From: Sue Howell
Sent: 18 October 2017 17:00
To: Planning.Responses
Cc: Michael Eastham
Subject: RE: Planning Consultation on: BE/102/17/OUT

Comment from Greenspace

APPLICATION **BE/102/17/OUT**

Site Address: Salt Box Field Land Off Rowan Way Bersted
PO22 9NW

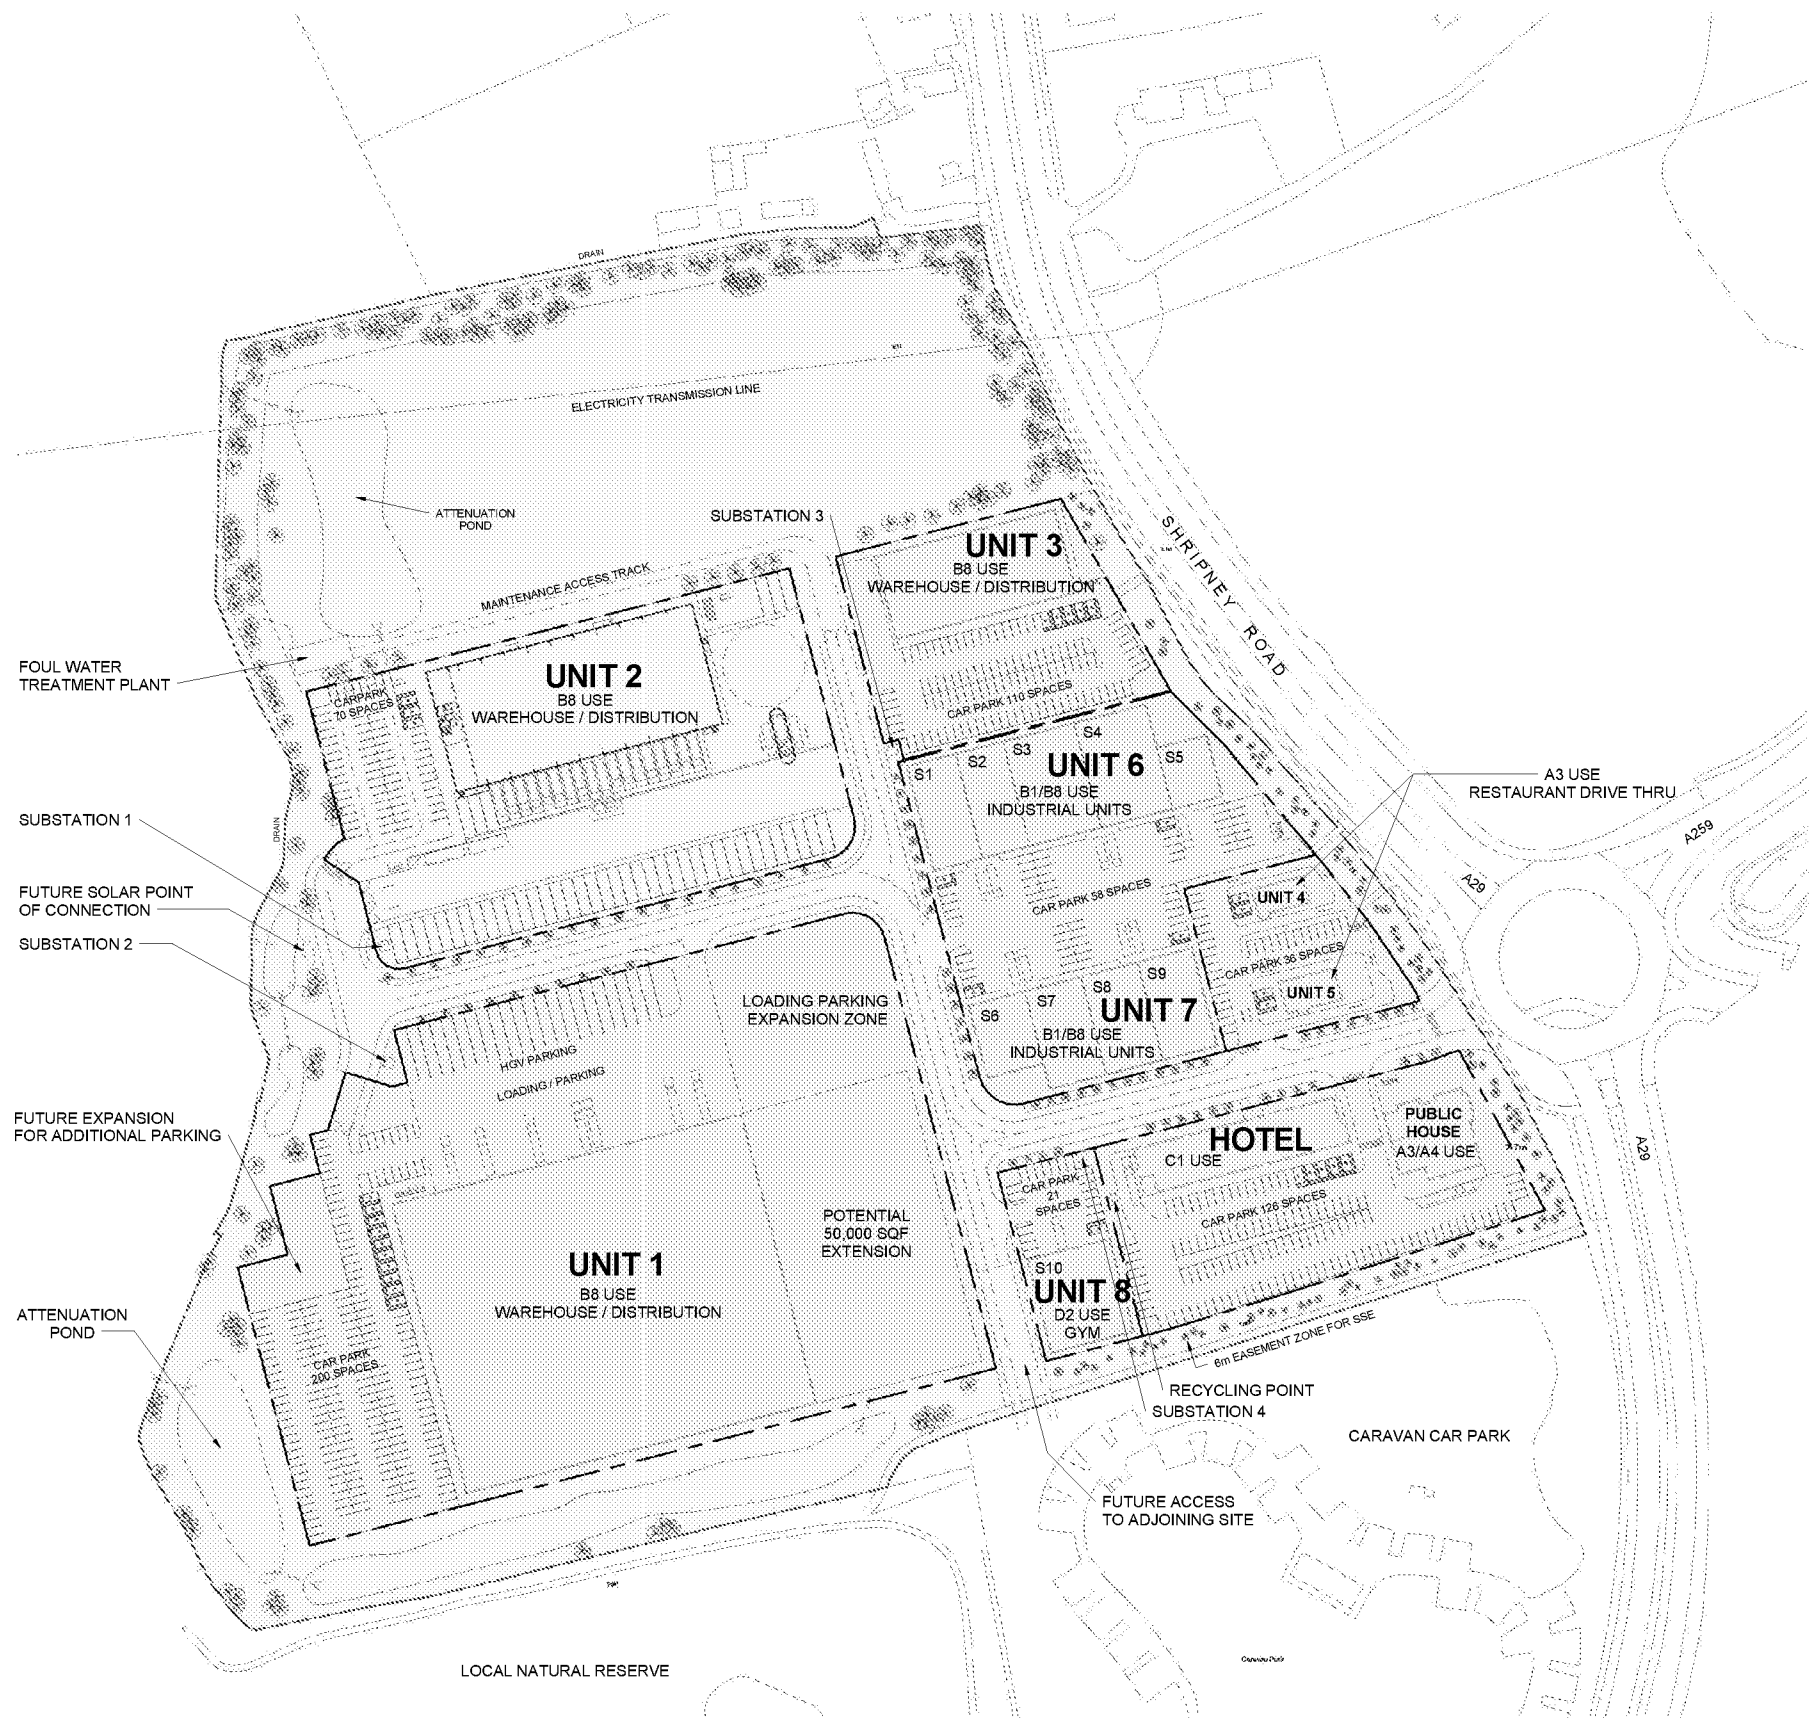
Site layout Masterplan proposed block plan drawing 1744-P02-A shows an indicative landscape scheme layout at this stage. Full planting plans will be required that detail a full landscape scheme to be submitted for approval. These will need to detail species choice, position, densities and size at time of planting. These should be plotted in plan and list form and in relation to the trees and vegetation to be retained so that a clear picture of the proposals can be seen. These details are required to ensure that appropriate screening is provided, maintaining and uncompromising the setting and ensuring that the proposals fit within the area of neighbouring development, the rural fringe and properties and neighbouring South Downs National Park, whilst benefiting the potential of the proposed developments usage.
